**RESPONSE TO STAGE 1 GREATER LONDON AUTHORITY FEEDBACK
DEMOLITION OF FORMER RESIDENTIAL SCHOOL AND ERECTION OF ACADEMIC BUILDING
(USE CLASS F1), LORD ADONIS HOUSE, HAREFIELD ACADEMY UB9 6ET**

I write further to comments received from the Greater London Authority (GLA). We are instructed by London Borough of Hillingdon to submit additional information related to the above planning application pending determination under reference 17709APP/2023/2673.

D09 Surface 05 - Permeable Asphalt - Section
0505 Scale: 1:20

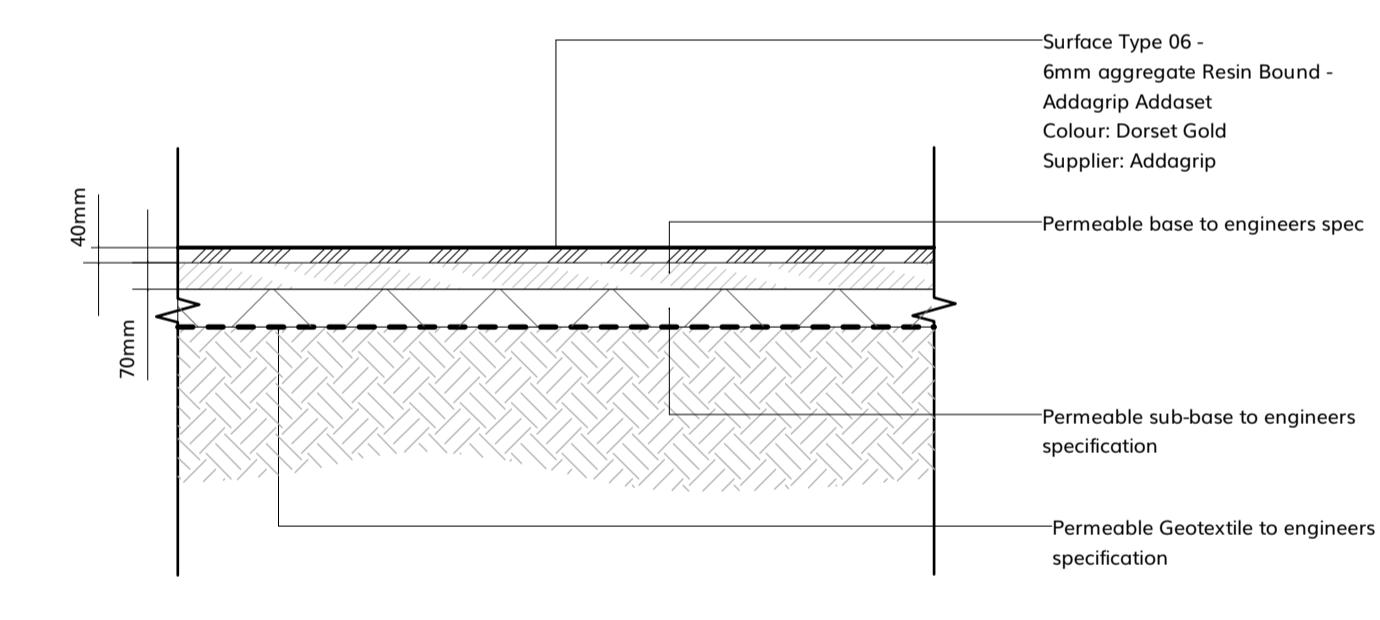
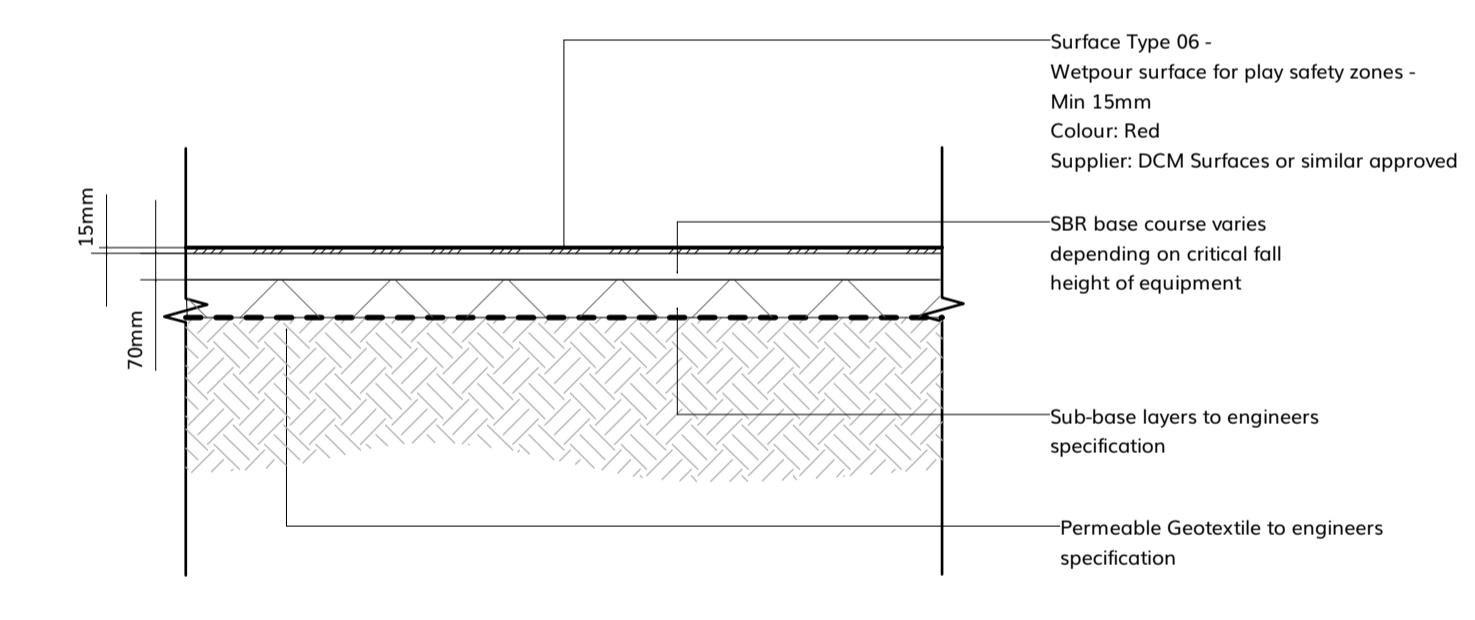
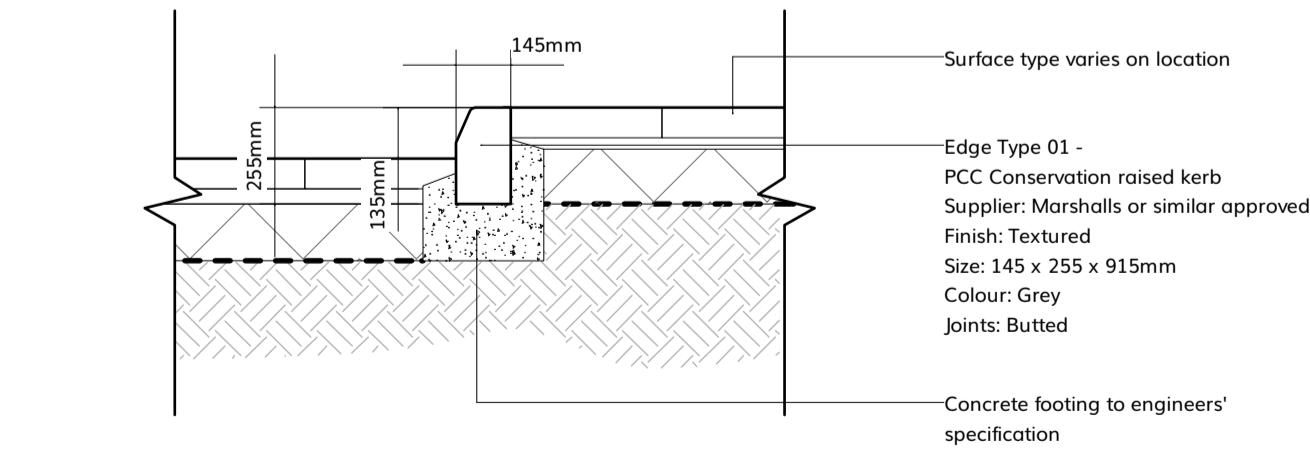
45/ "Although located within Green Belt land, the proposal includes a significant extent of sealed outdoor surfaces, including a new car park, access roads and play areas. The applicant should seek limit the use of sealed surfacing as much as possible, by limiting the extent of hard surfaces. Where hard surfaces are required, permeable surfacing should be deployed."

The design of external spaces needs to ensure that sufficient hard surfacing for functional/play areas in order to not affect BB104 areas. The approach taken has been to accommodate hard surfacing within the site area without encroaching further into Green Belt land. Wherever possible, soft landscaping has been incorporated to ensure an appropriate balance is reached with BB104 requirements. The design proposes permeable paving and asphalt throughout the site, around the building and play spaces. However, this does not include the access road and parking area, but the direction of runoff will be directed into soft planting where achievable.
